Re: **9021 Chicago Avenue-Drainage Memo**
Project No. 61214

Please include project No.
PPR2428

The purpose of this Drainage Memo is to satisfy the drainage submittal Requirement of the Pikes Peak Regional Building Department (RBD) for the construction of a 20' x 40' shed to be located at 9025 Chicago Avenue, Town of Falcon. The new address for the shed is 9021 Chicago Avenue. The site with the proposed shed location is shown on the attached sketch layout of the site. The site is situated south of Chicago Avenue at the intersection of 5th Avenue in the Town of Monument. The owner is requesting the construction of a 20' x 40' shed. This Drainage Memo is prepared in accordance with the provisions of the City of Colorado Springs Stormwater Enterprise and DCM Volume 1 and 2 and the Engineering Criteria Manual. El Paso County Engineering Criteria Manual and Land Development Code as amended.

**SITE PLAN
&
DRAINAGE PLAN**
(Flow Direction)
(Proposed Shed Location)

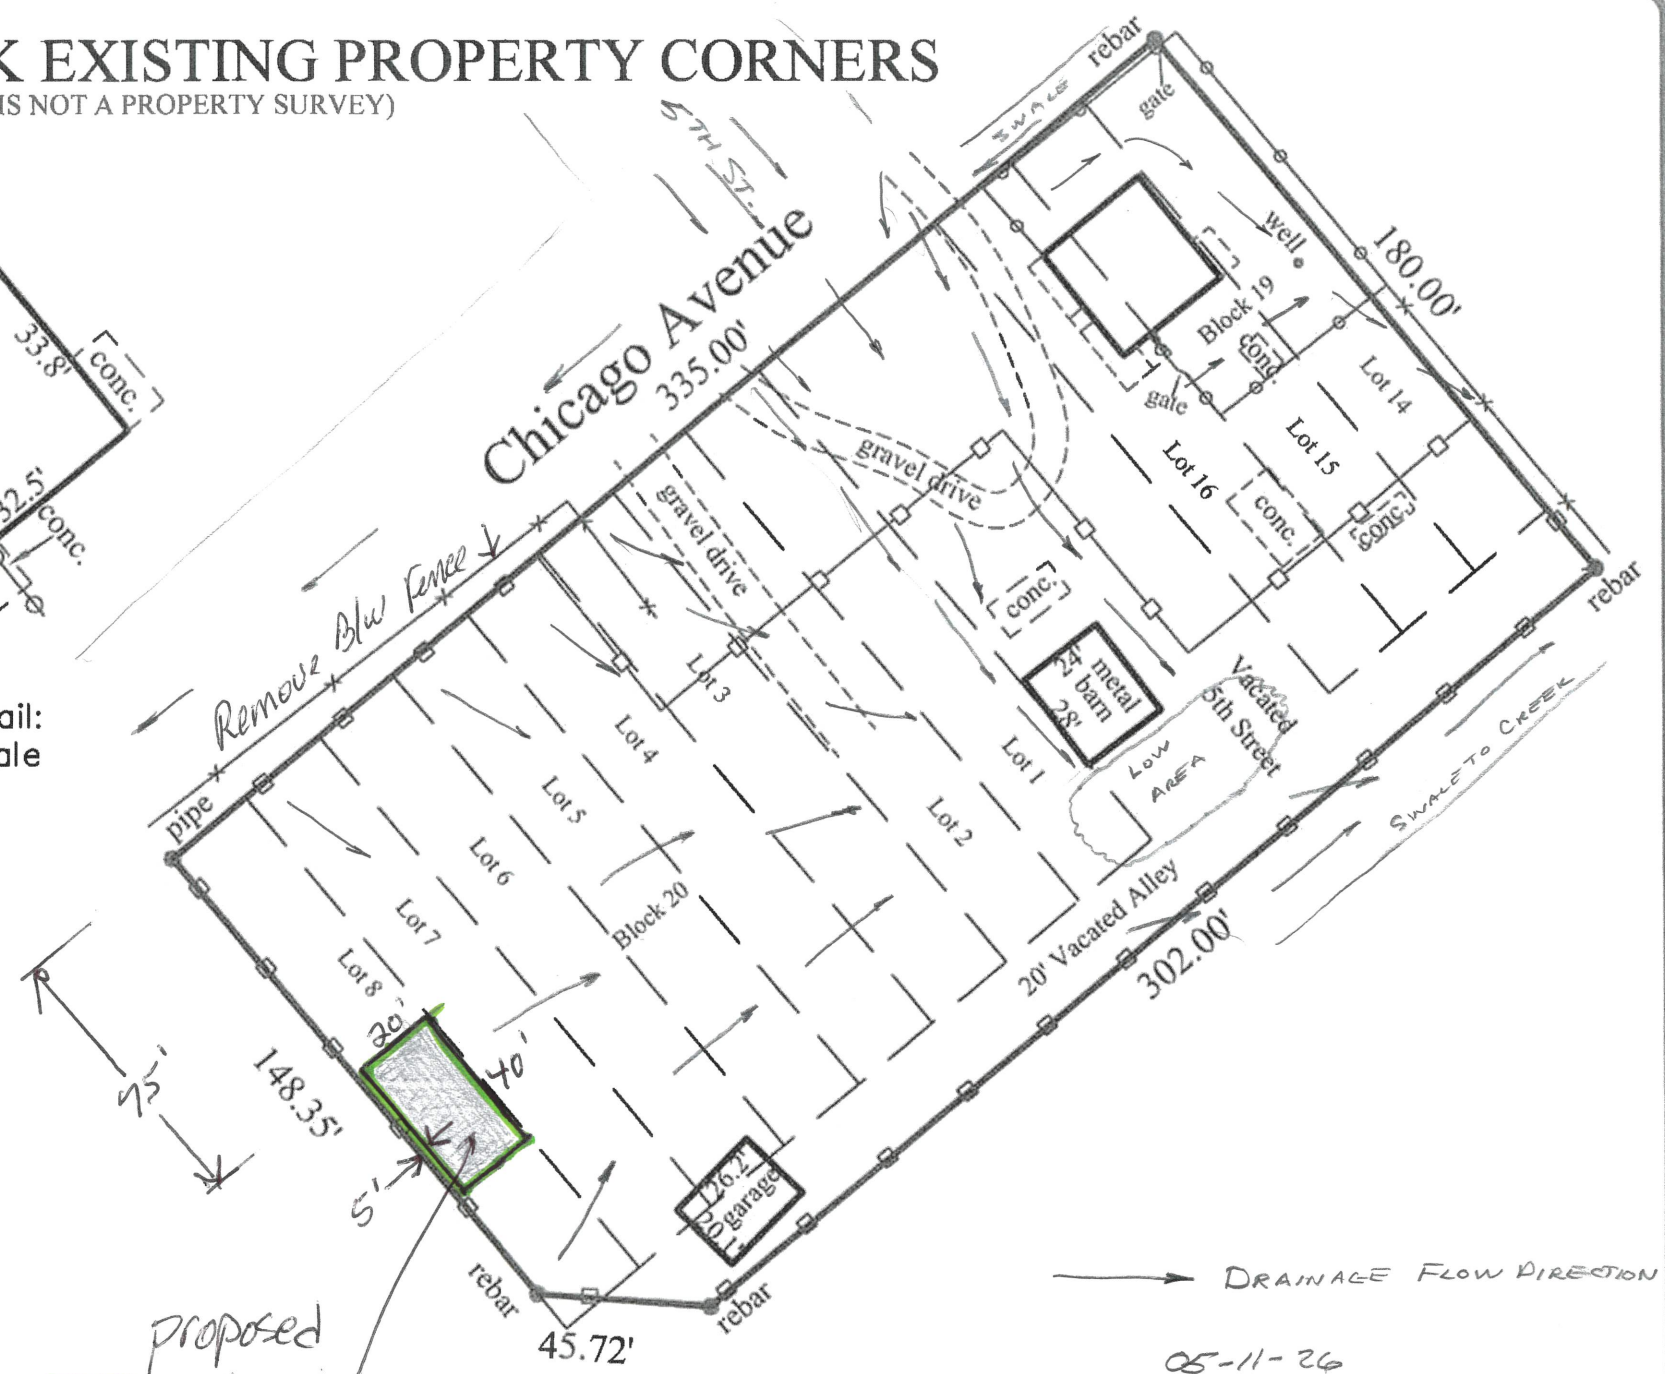
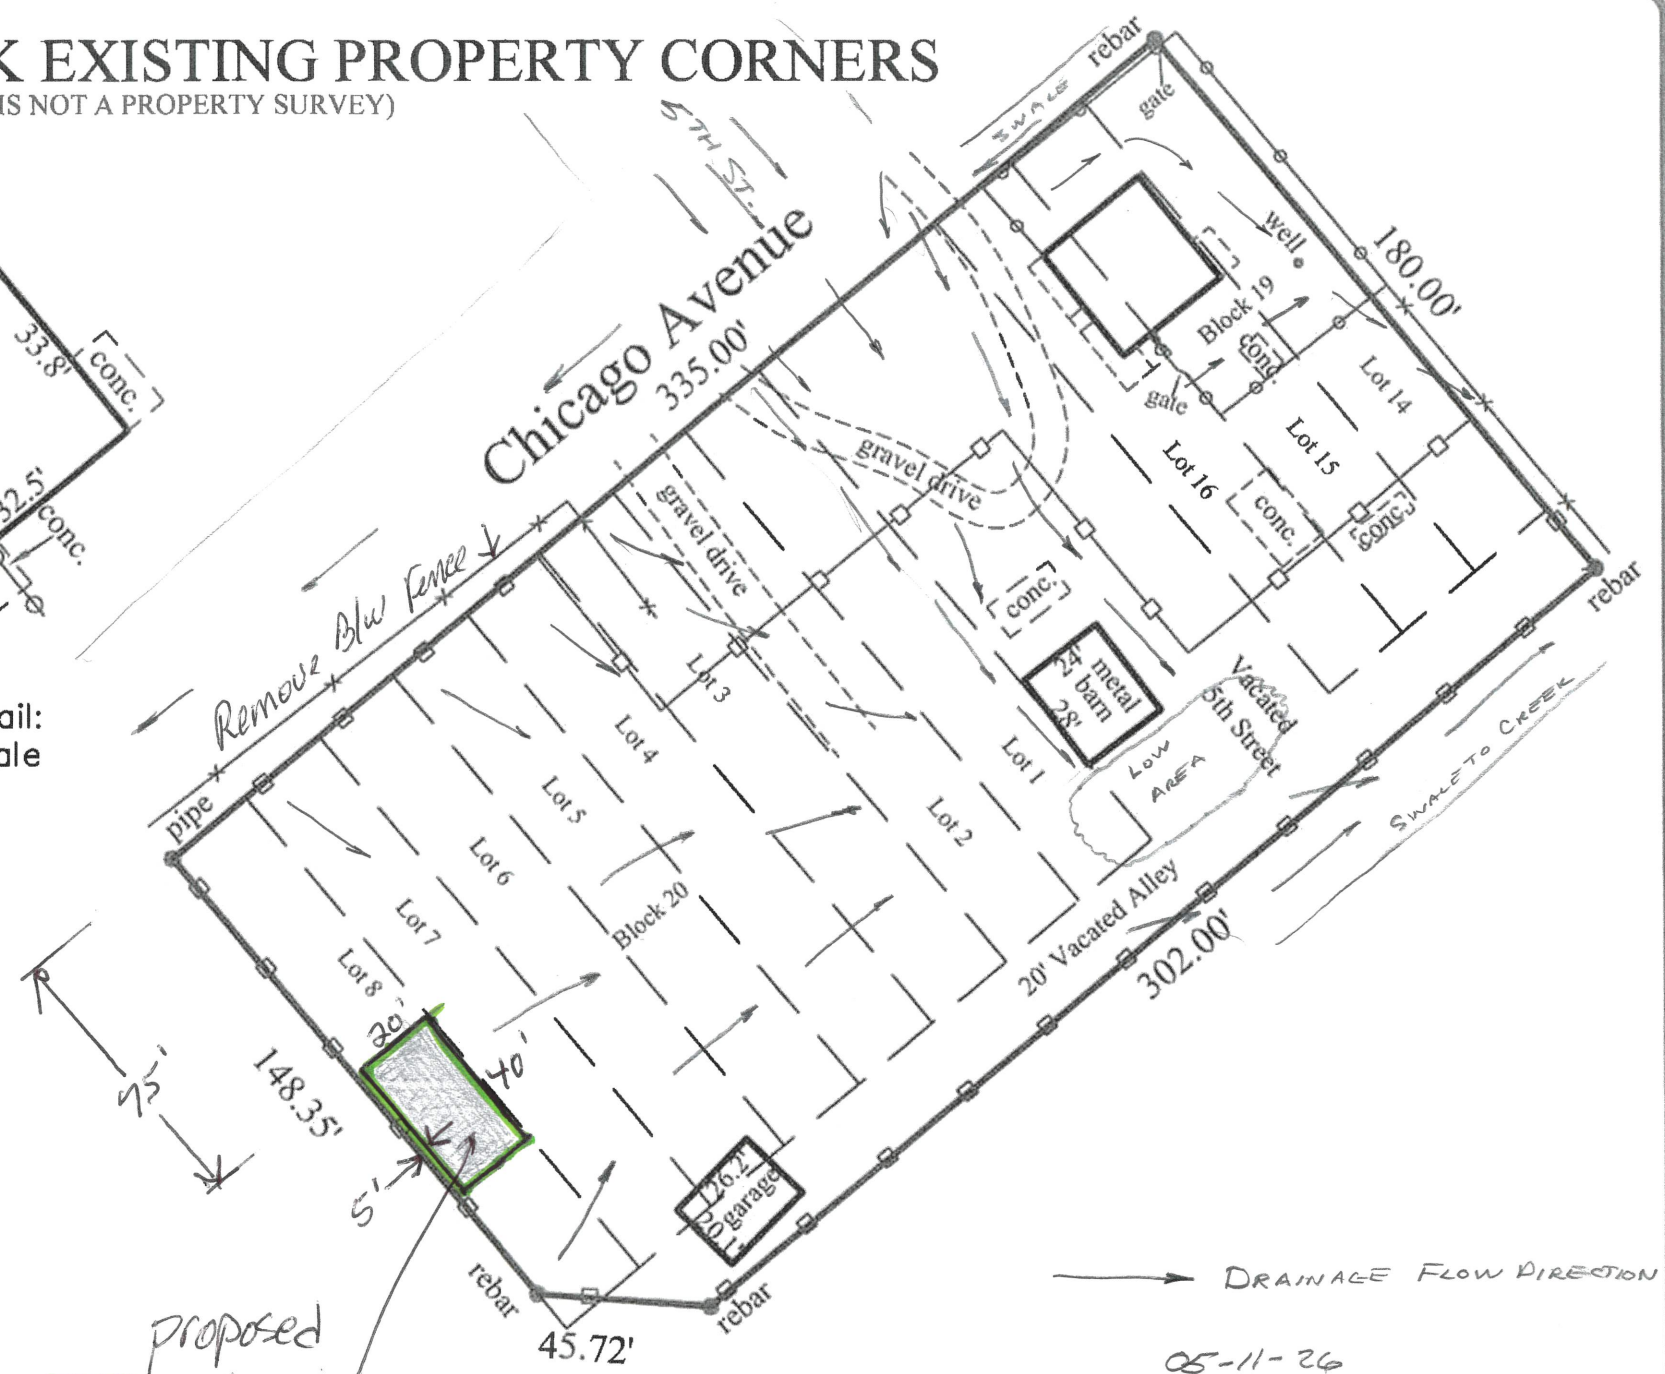
Drainage maps are required to show the direction of stormwater flow for the area before and after the project proposed.
